Application No: LU/206/21/RES
Registered: 26th July 2021
Site Address: Phase 5 Hampton Park Toddington Lane Littlehampton BN17 7PL
Grid Reference: 503311 103690
Description of Works: Approval of reserved matters following outline consent LU/47/11/ for the development of 260 No. dwellings and the construction of the Central Spine Road running through Hampton Park. This site is in CIL zone SP2 and is not CIL Liable as strategic site.

title
PROPOSED CENTRAL WETLAND SWALES
CONSTRUCTION DETAILS

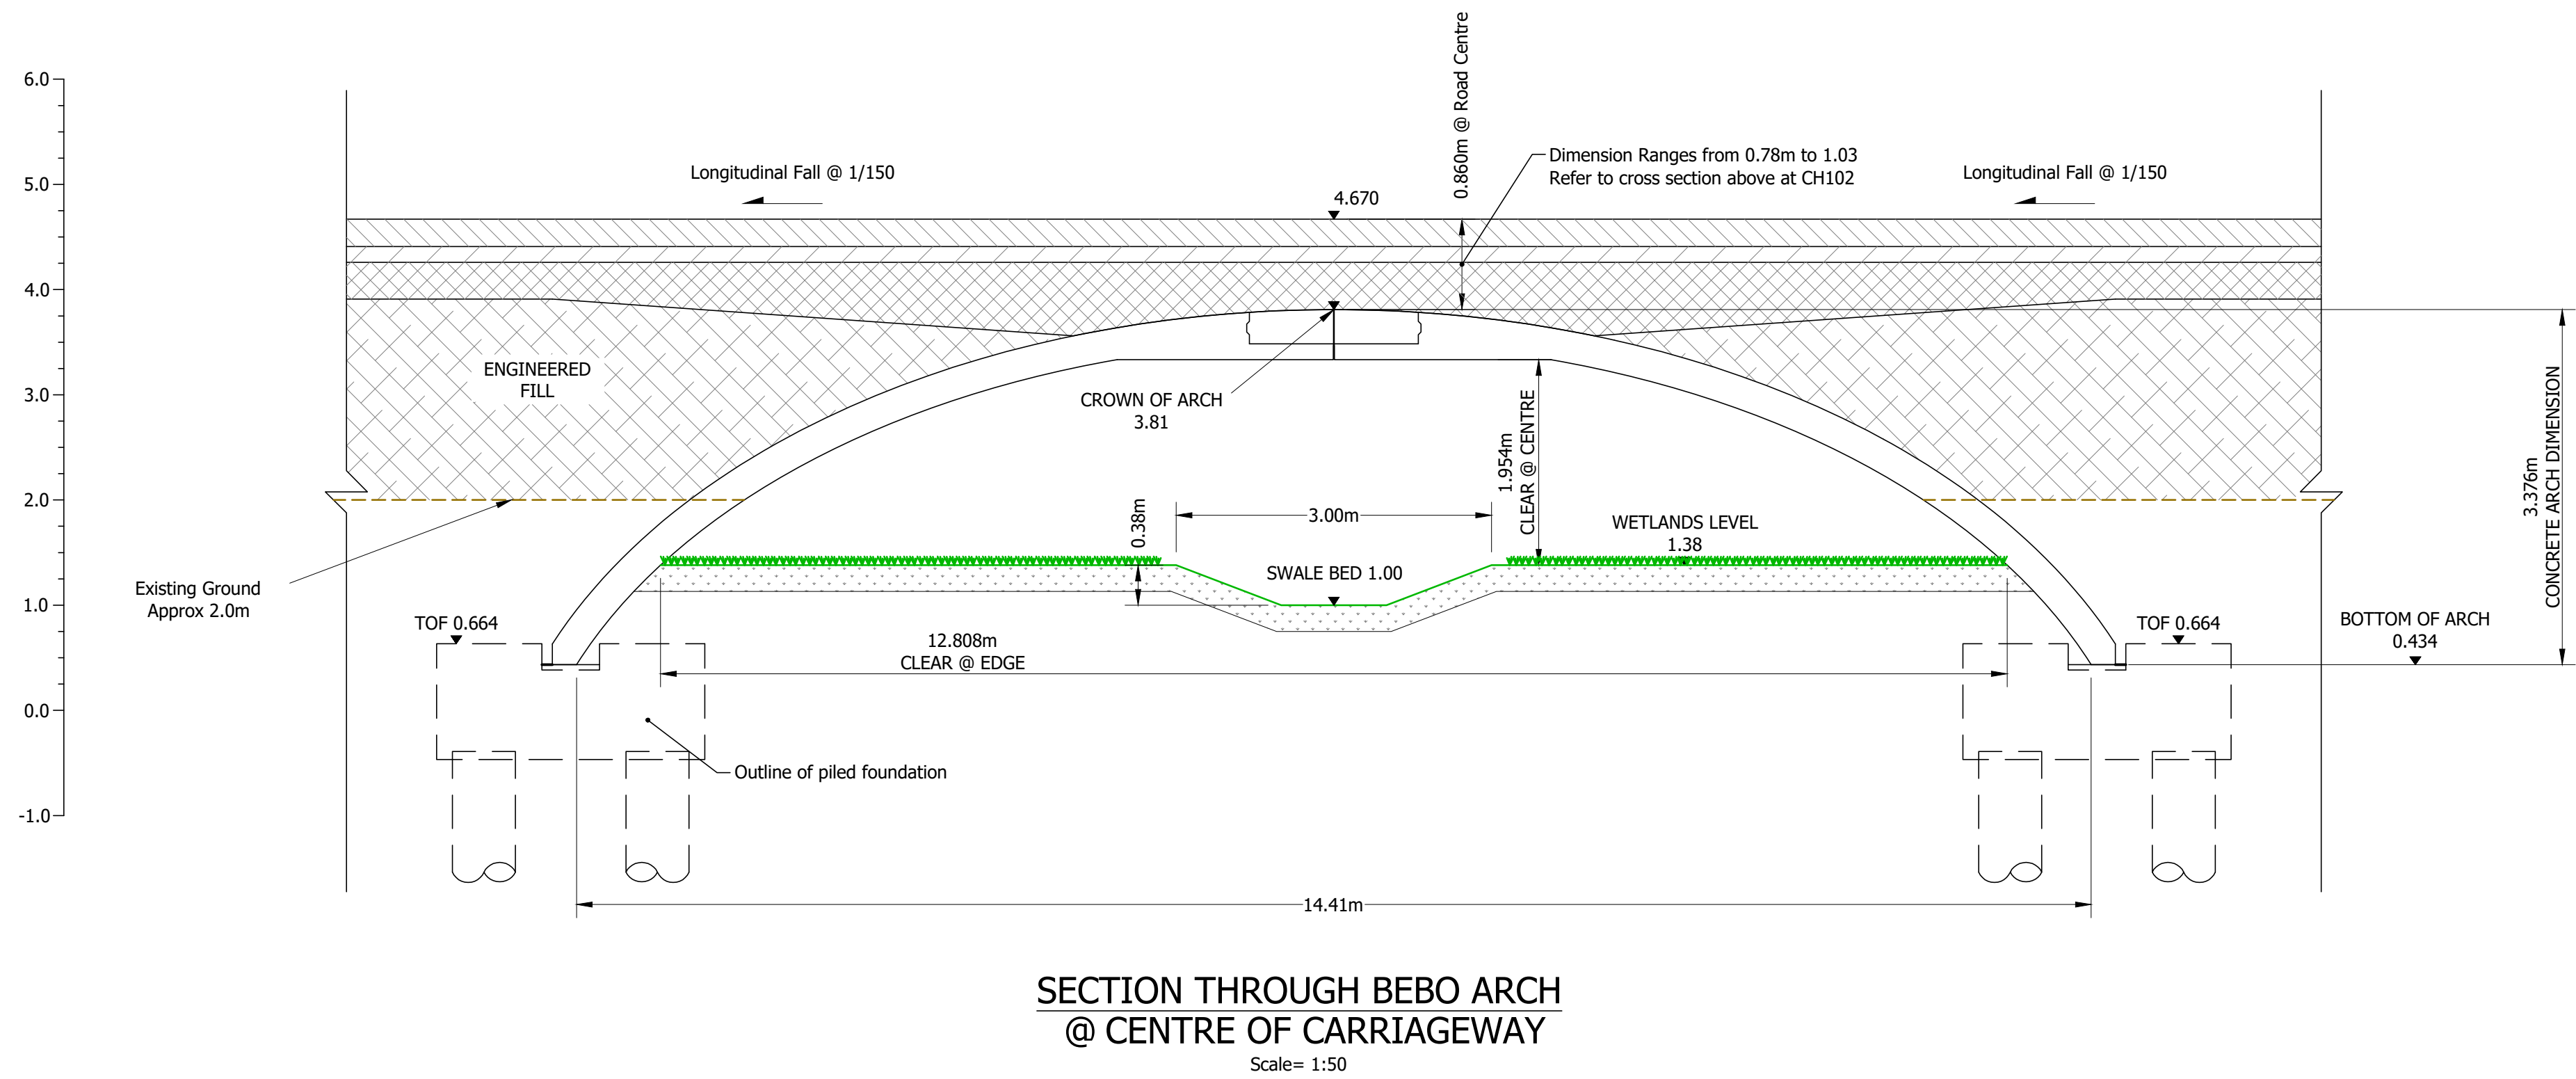
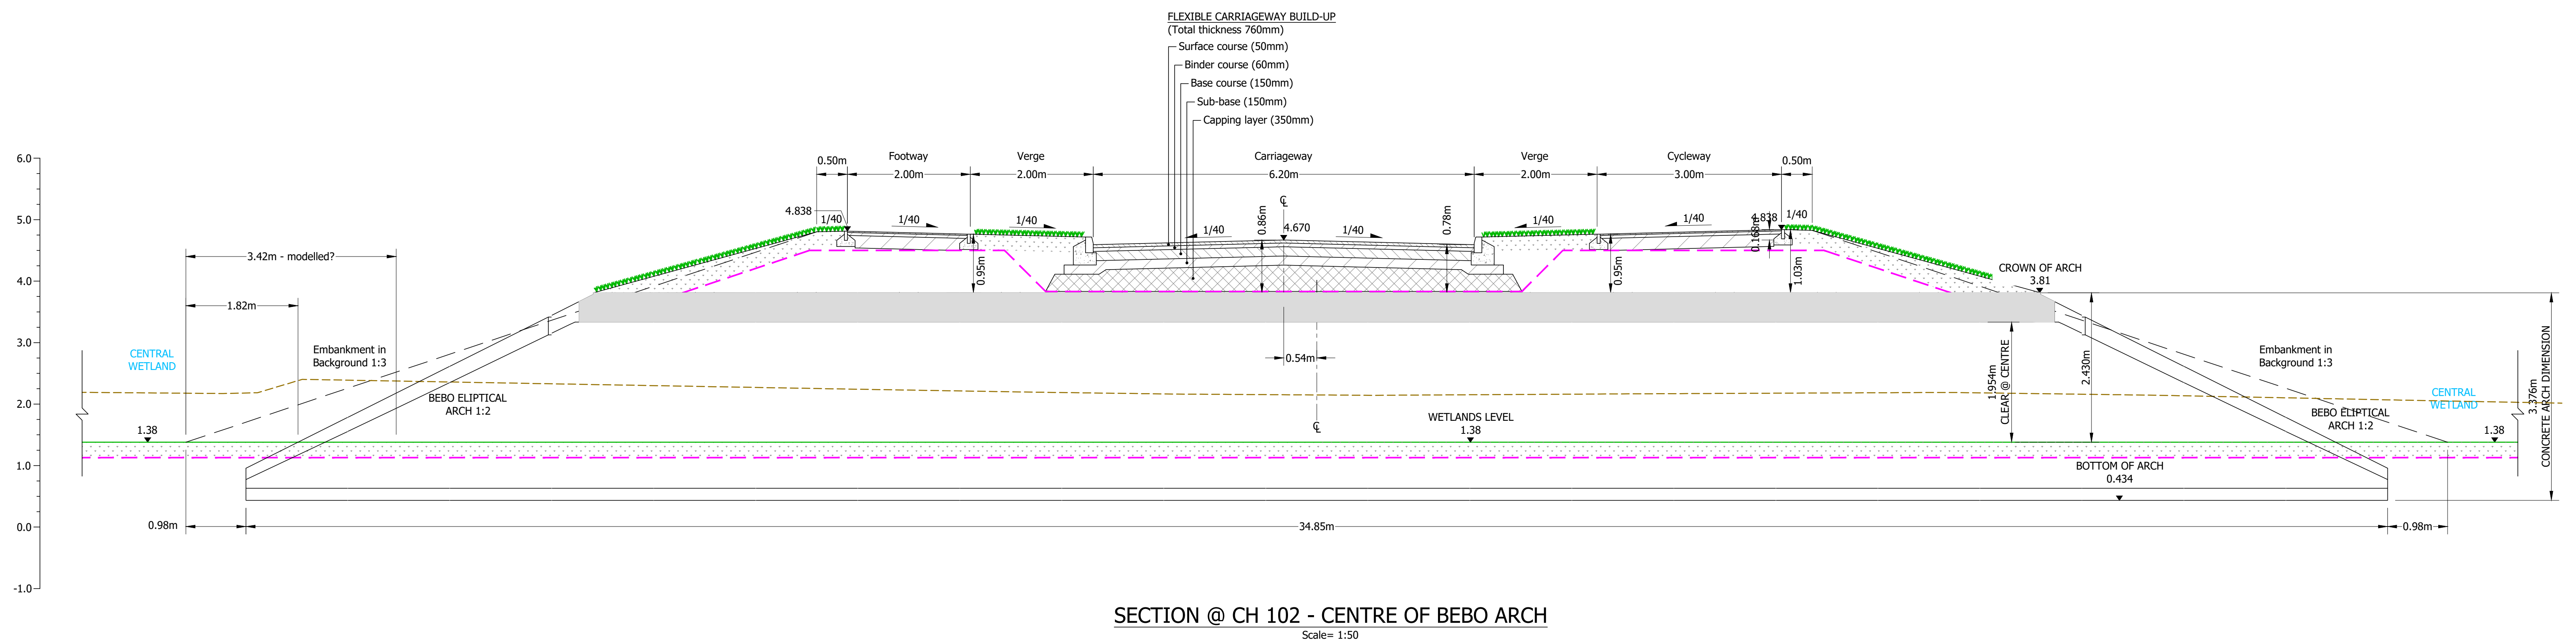
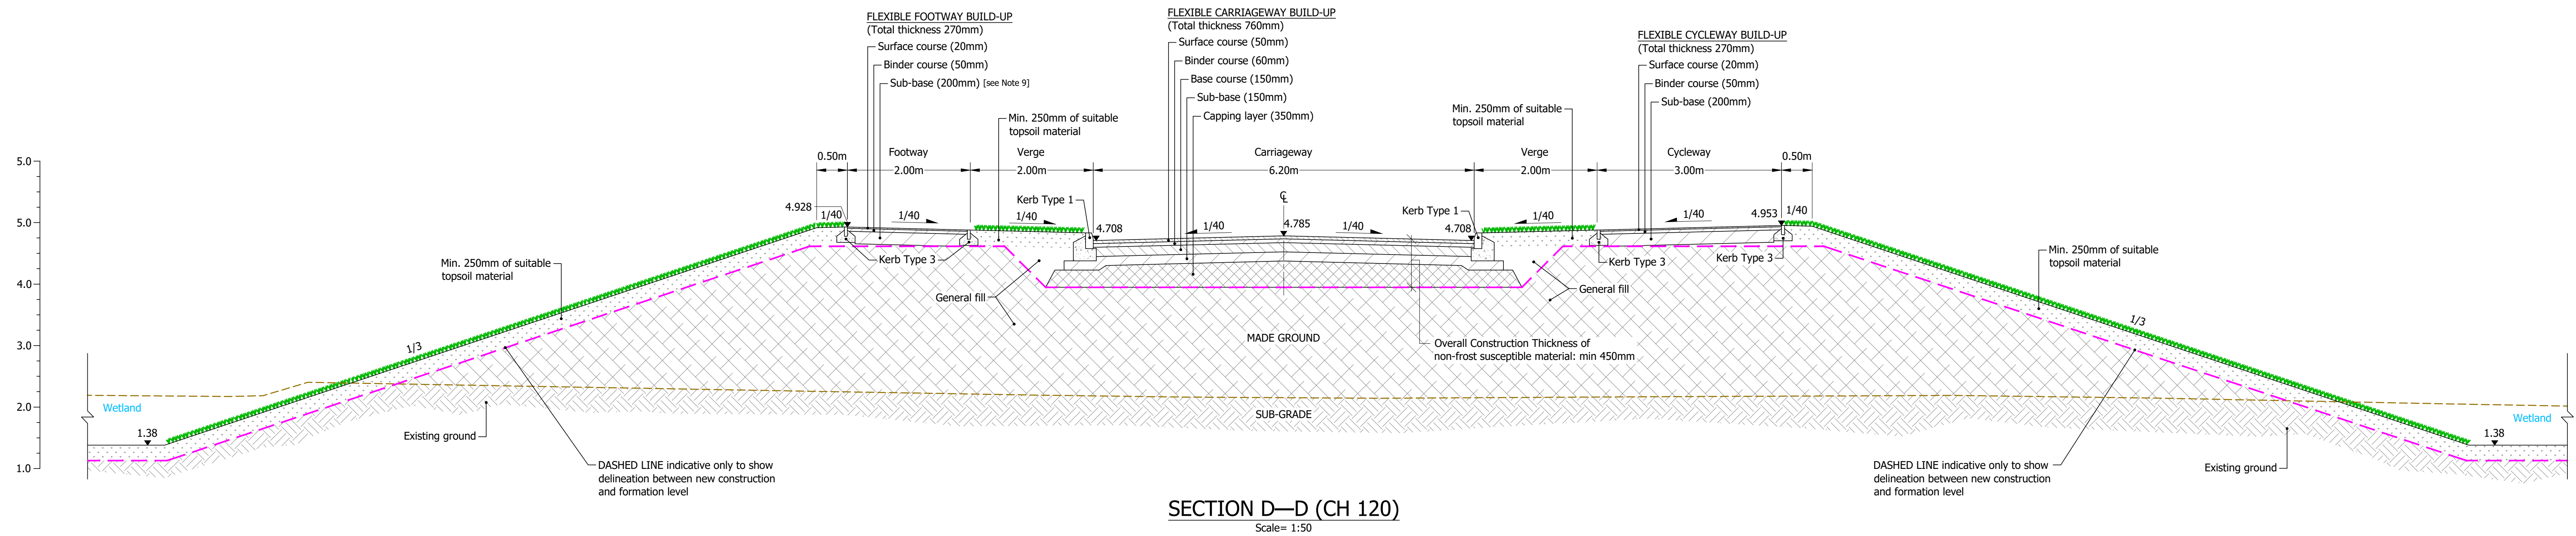
The Ecological mitigation management plan (June 2021) has not submitted a scheme for the proposed central wetland. We would like to see the scheme for this to be created/restored, including the location and timings of restoration.
